**Santa Sophia Catholic College (SSD-9772)  
Response to Submissions**

## **ATTACHMENT 1 - KEY ISSUES**

Figure 2 – Height Plane –Surrounding Development Context

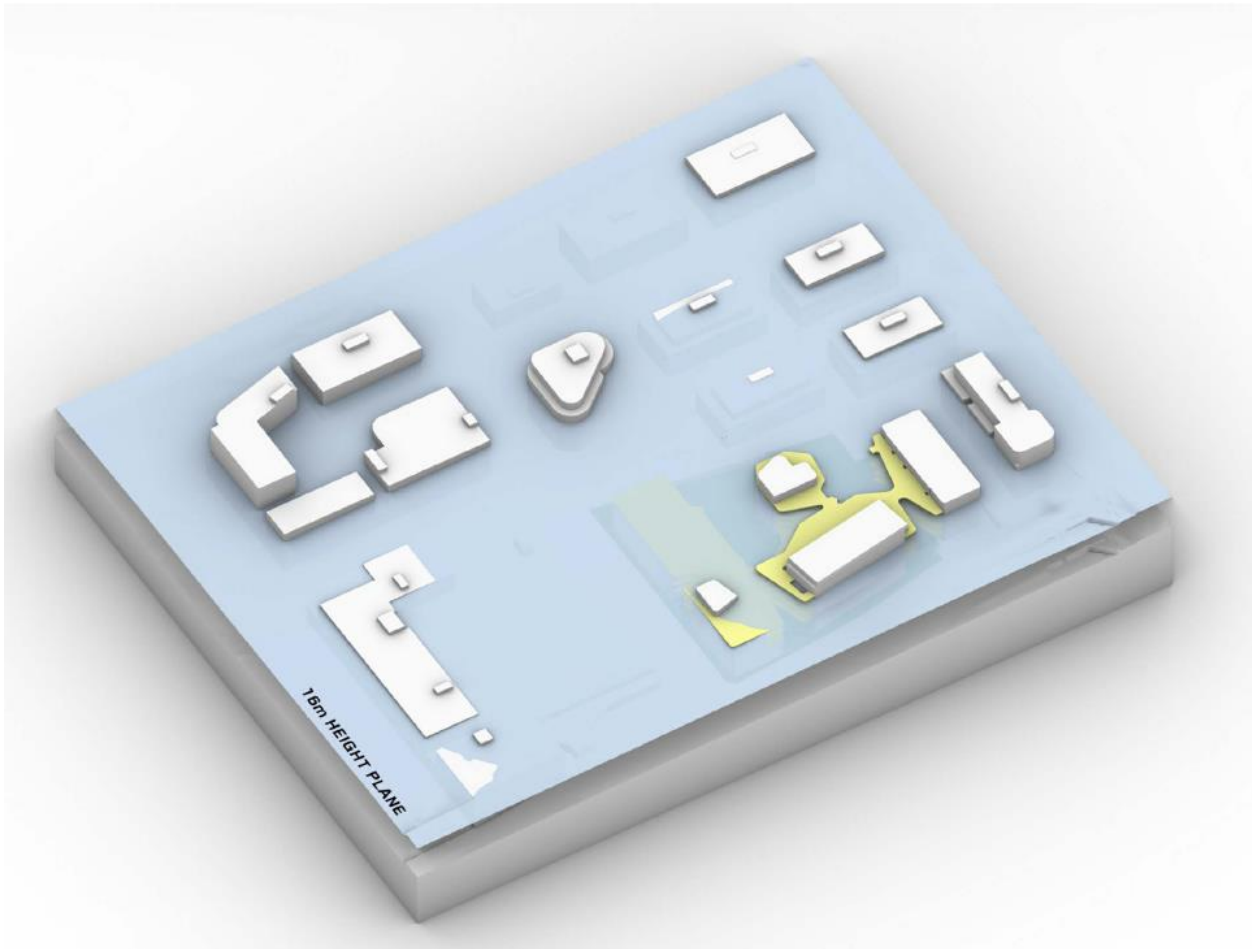
3. The proposed development relies upon an undetermined planning proposal to justify the height and floor space of the proposed buildings and generally argues that increased height of these buildings would allow more open space to be provided on the site. The Department considers that the site would be dominated by the proposed built form and that insufficient open space would be provided for students. A clause 4.6 variation request is required to address any height variation of the proposed development compared to the controls of the adopted Local Environmental Plan.
4. Changes recommended by the Government Architect NSW (GANSW) at the state design review panel have not been adopted in the most recent version of the proposed development. Further consideration must be given to these recommendations.

Figure 3 – Elevation Study – Future Building 4F – Mid Winter

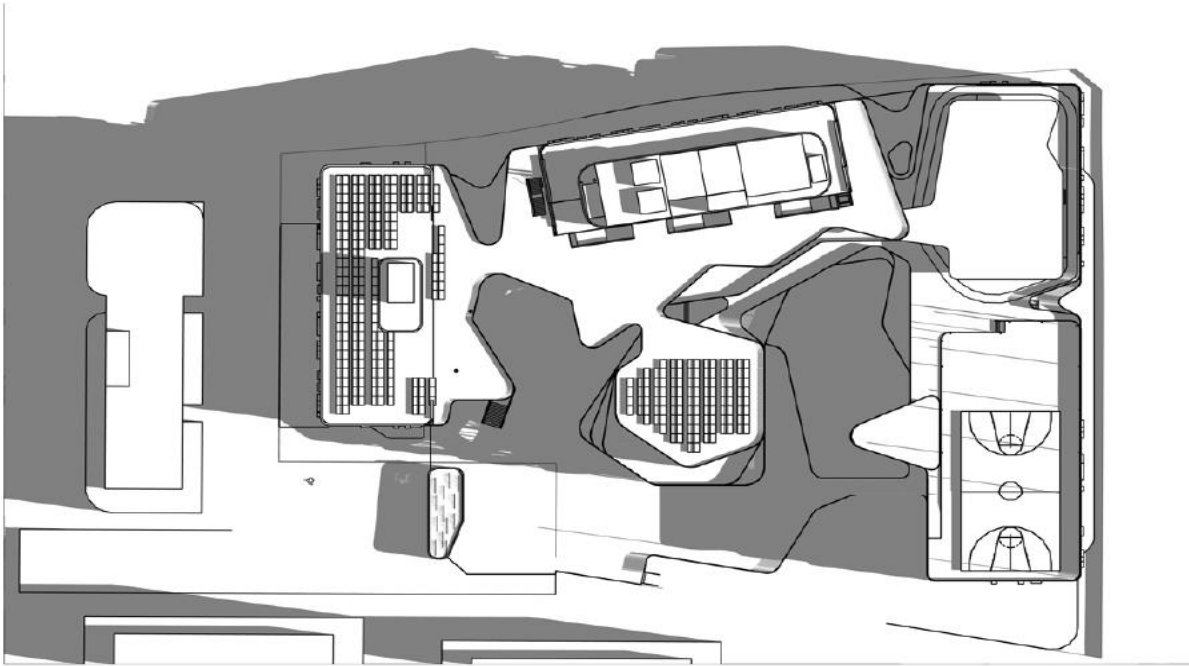
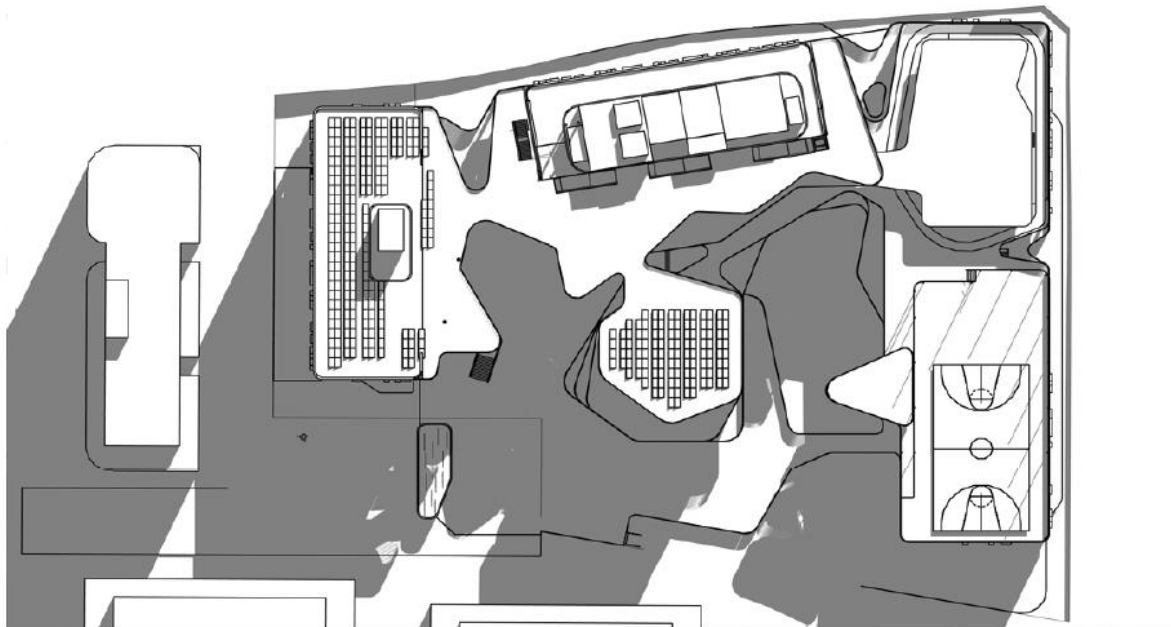
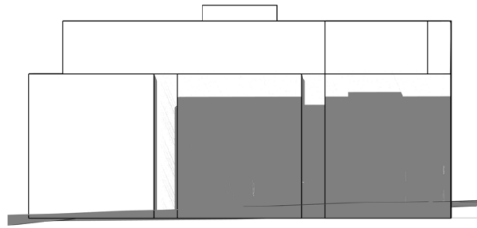
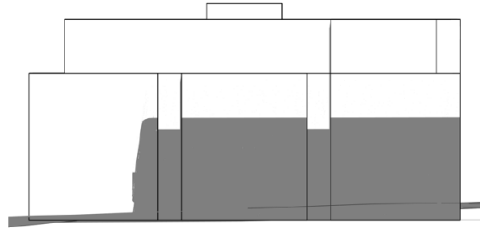
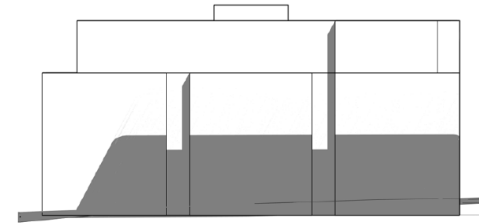
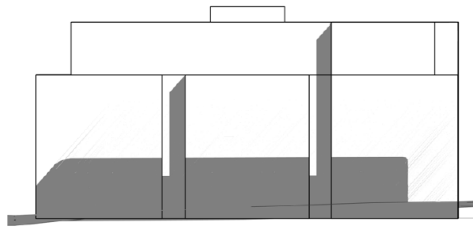
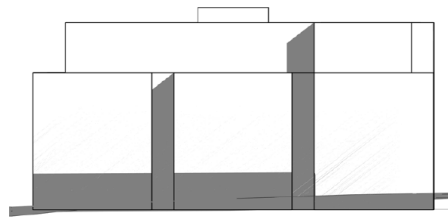
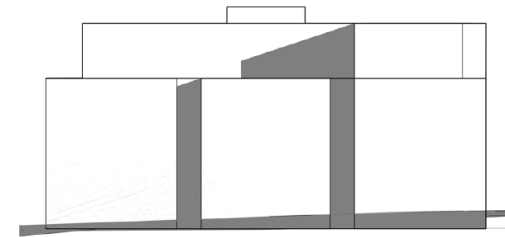
9. The proposed southern school building would have overshadowing impacts on the future residential apartment building adjacent to the site. During winter months some lower level apartments may receive less than 2 hours of sunlight during the day. As a result, any future residential development would be unable to meet the requirements of State Environmental Planning Policy No 65 - Design Quality of Residential Flat Development in relation to solar access. This is a poor design outcome for a greenfield development site and the proposal must be redesigned to give appropriate consideration to the overshadowing impacts to future adjoining residential development.

Figure 4 – Secondary Pickup Dropoff

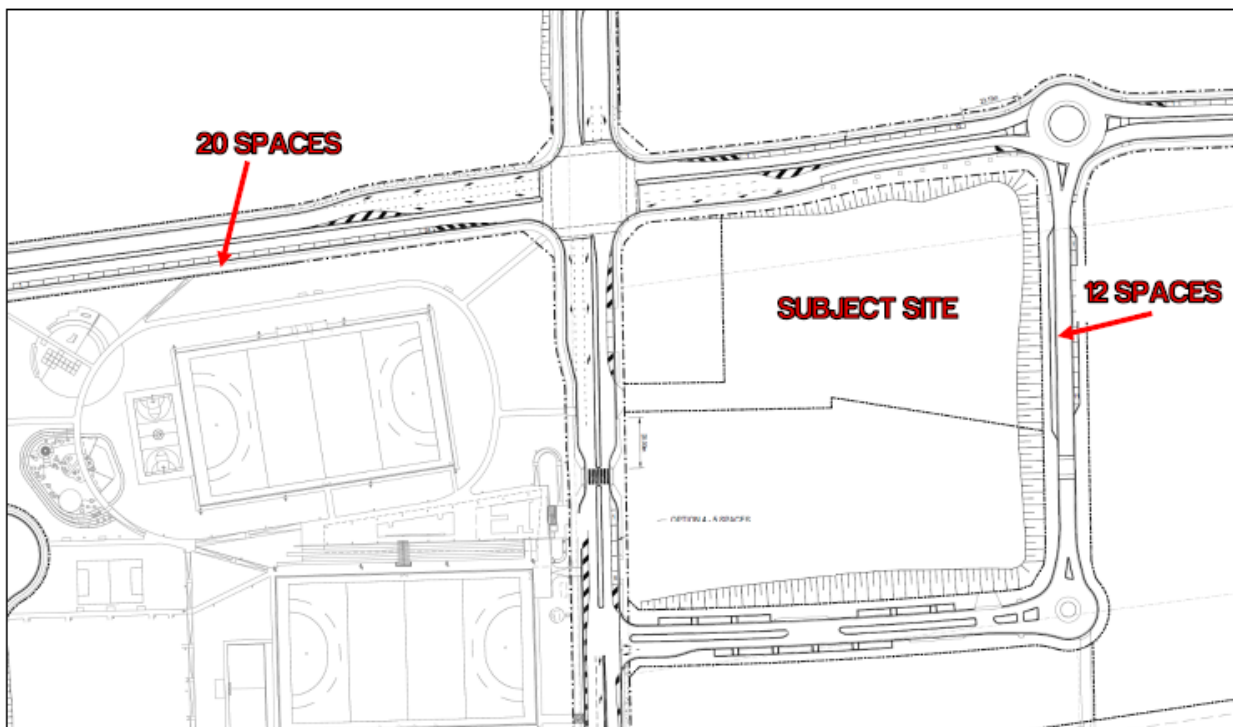
7. The Transport and Accessibility Impact Assessment submitted with the EIS identified that the proposed drop-off/pick-up area would be insufficient for the proposed maximum capacity of the school. Additional drop-off/pick-up spaces should be provided, or robust evidence submitted which demonstrates that the number of drop-off/pick-up spaces would be adequate for the proposed size of the development.
